CITY OF ELLENSBURG

Memorandum

Date: June 28, 2005
To: Joanna Valencia, Kittitas County Planning Dept.
From: Gordon Crane, Engineering Department *GC*
Through: John Akers, City of Ellensburg Public Works Director *JA*
Re: proposed 187 lot Vista View Plat development proposal

VISTA VIEW ESTATES
PTN. SE 1/4, SEC. 1, T.17N., R.18E., W.M.
KITITTAS COUNTY, STATE OF WASHINGTON
DWN BY S.K./G.W. DATE 02/05 JOB NO. 04663
CHKD BY D.NELSON SCALE 1"=150' SHEET 1 of 3

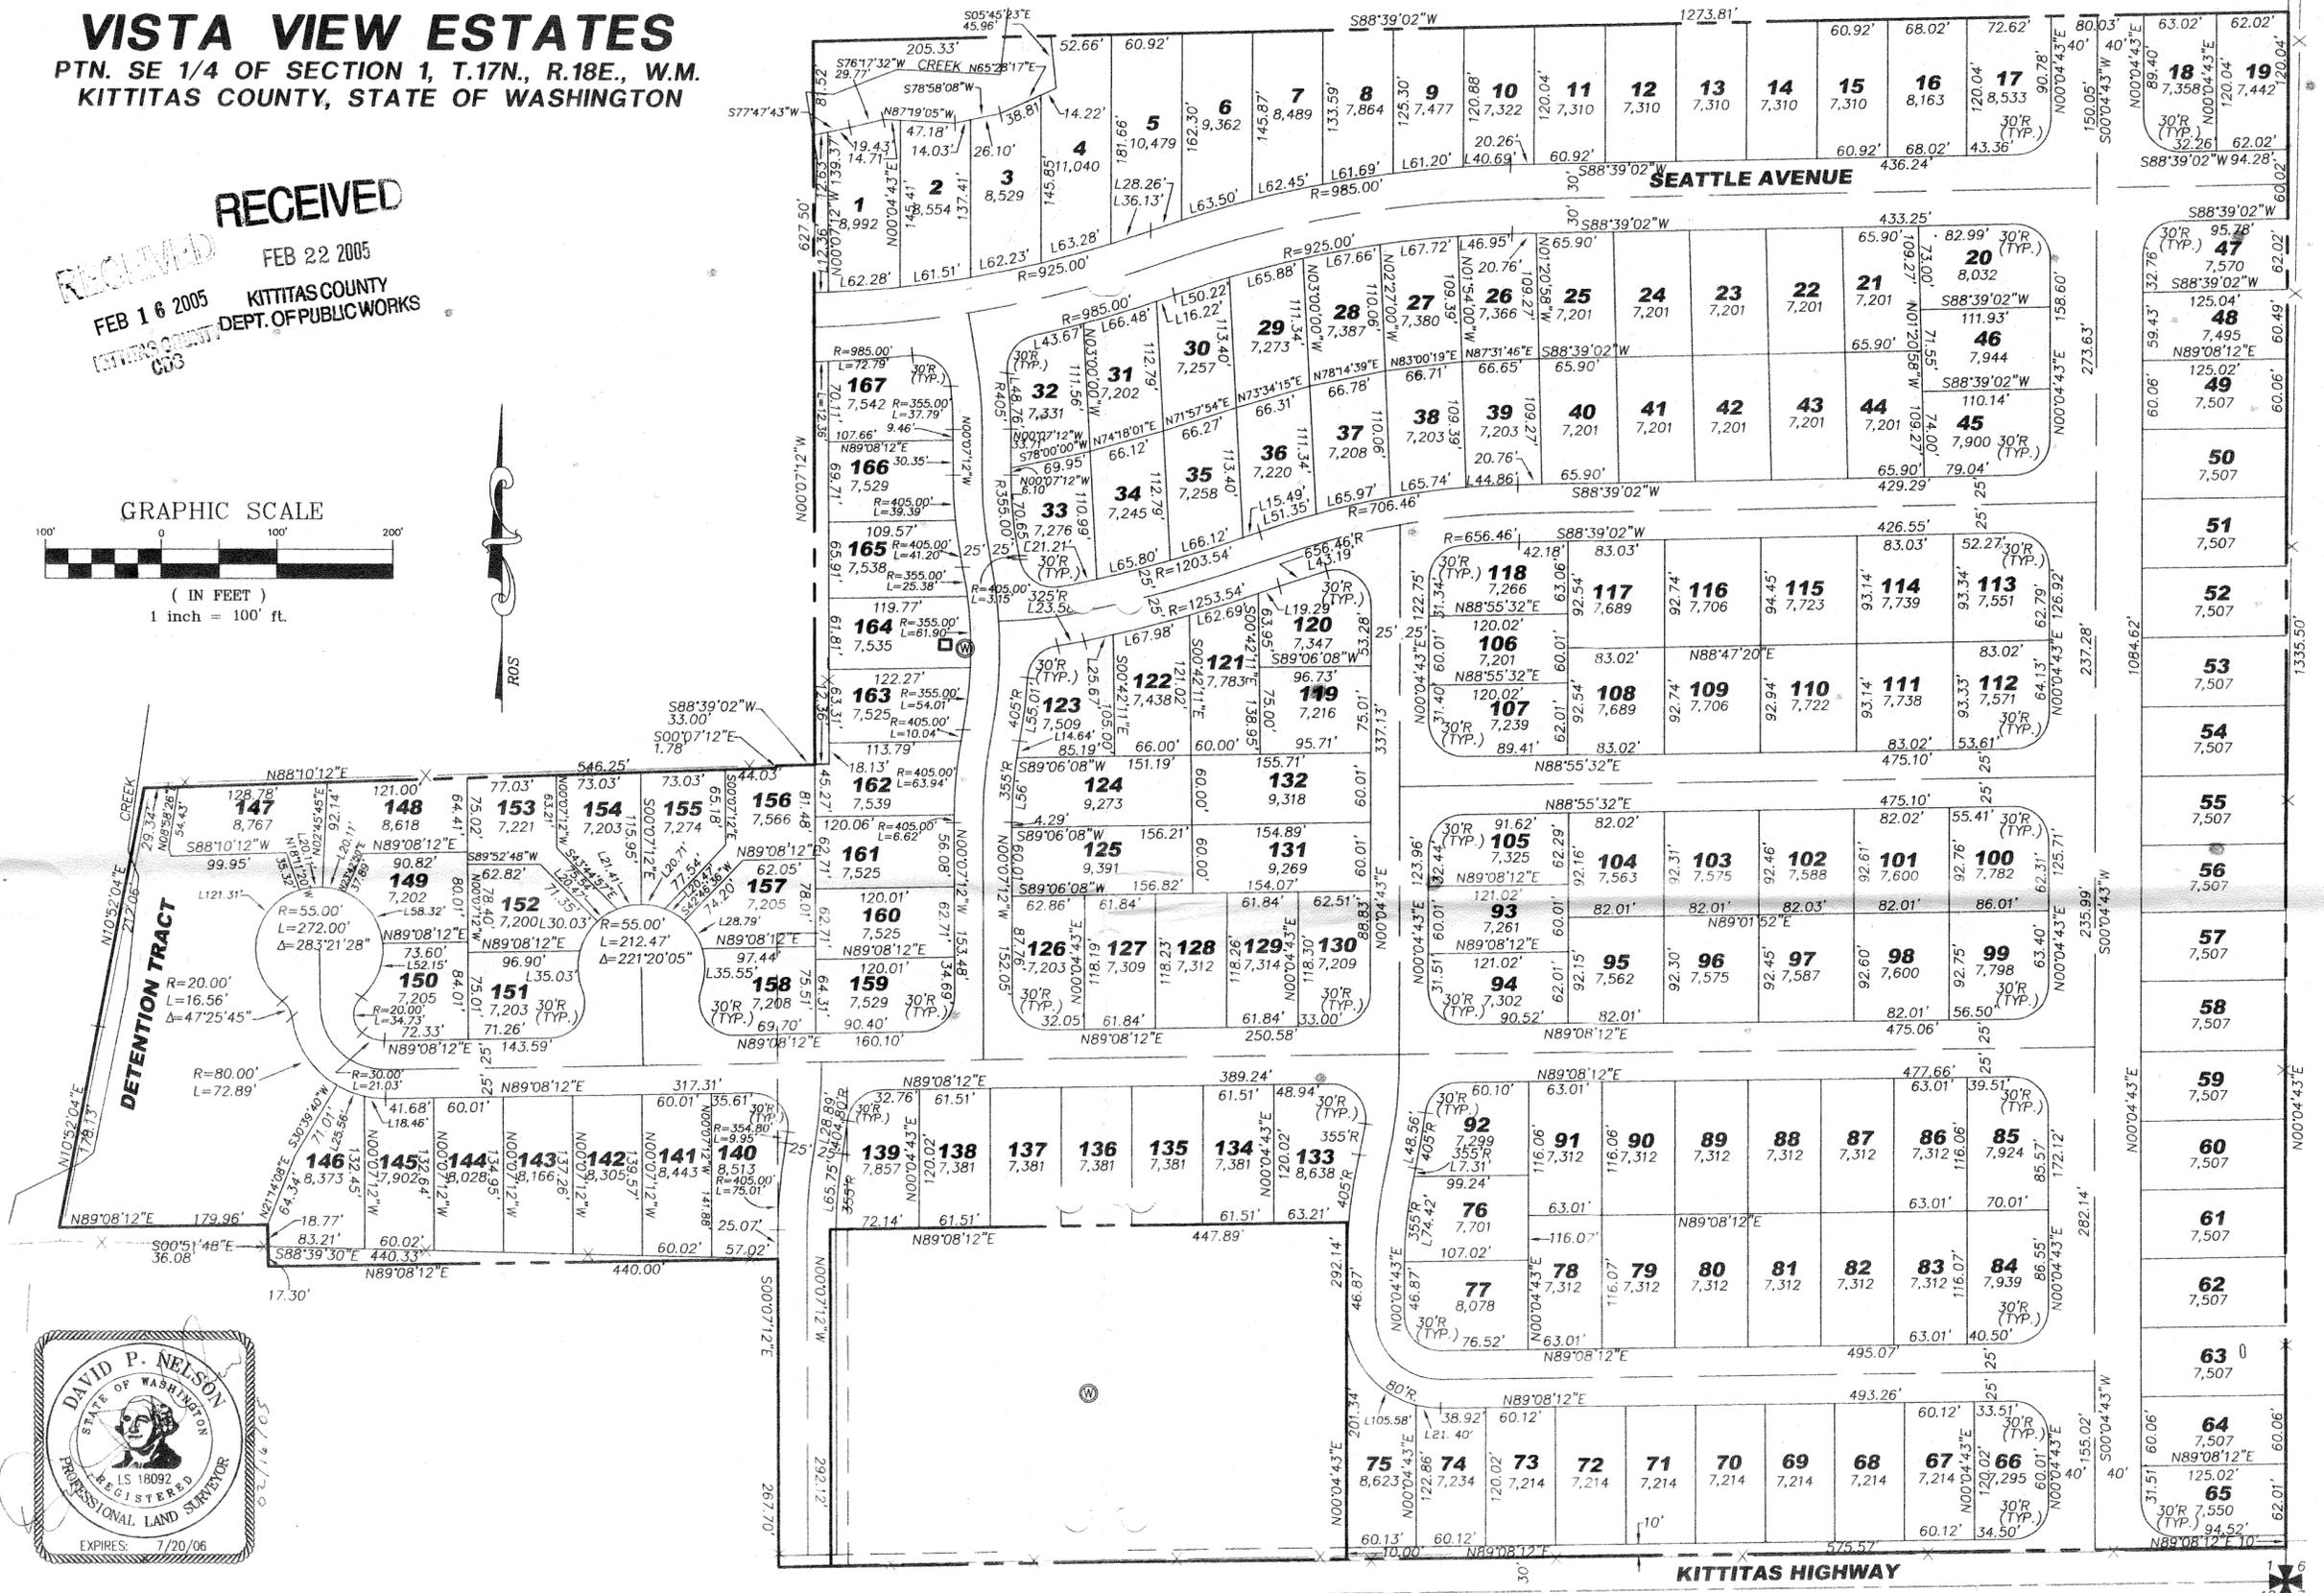
The SEPA application notes 4 phases for the plat. The drawings submitted do not indicate phasing lines. Specific civil plan phasing issues will be reviewed at time of civil plan submittal.

The preliminary plat indicates a detention area for storm water detention and flow control. Specific issues related to storm water will be reviewed at time of civil plan submittal.

Road names should comply with the City's road name ordinance. Several roadways within the plat line up within existing City and County roadways or the address block grid. Starting from the south, the first east/west roadway will need a new "Avenue" name proposed by the developer. The next roadway north aligns with Hobert Avenue; the short bulb portion and cul-de-sac will bear the same name and have Hobert Avenue addresses assigned to the lots. The next short east/west roadway will need a new "Avenue" name proposed by the developer. The next roadway north aligns with Spokane Avenue. The roadway that aligns with Seattle Avenue will be called Seattle Avenue. For the north/south roadways, the most westerly roadway will need a new "Street" name proposed by the developer. The next short roadway lines up with Oak St. The easterly roadway will be Pfenning Road.
